Subject: FW: 22 Beach Road, Littlehampton.

Figure 4. Internal Measurement Positions

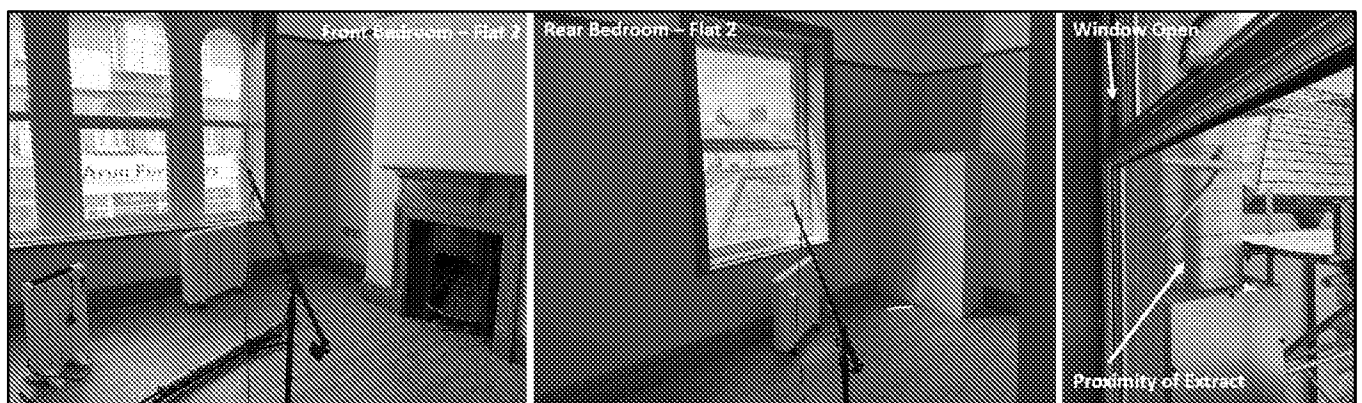
The reverberation times were measured in each of the locations where the surveys were undertaken. As noted from Table 3 in the report, the front bedroom in flat 2, was considerably higher in terms of reverberation than the smaller two bedrooms measured. As per Figure 4 of the report, the image displayed on the left hand side shows the laminated floor already laid.

Figure 7. Review of 1-hour periods inside Flat 1 bedroom

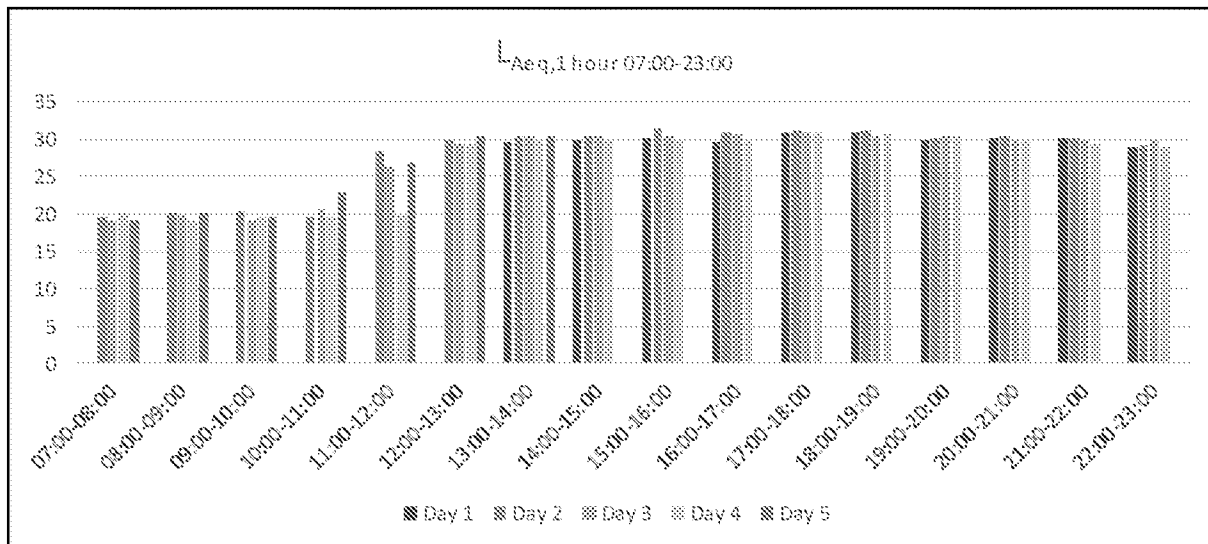
In respect of your report, 23rd August, page 3, paragraph 3 then to clarify, my comment related to **Figs 6 & 7** and **Flat 1** where daytime noise was found to be 28.8 with windows closed and therefore 39 to 44dB with reasonable adjustment for an open window.

Figures 6 and 7 in the report relate to Flat 1, however the references to 39 and 44dB relate to Flat 2, front bedroom, which is reported in Figure 10.
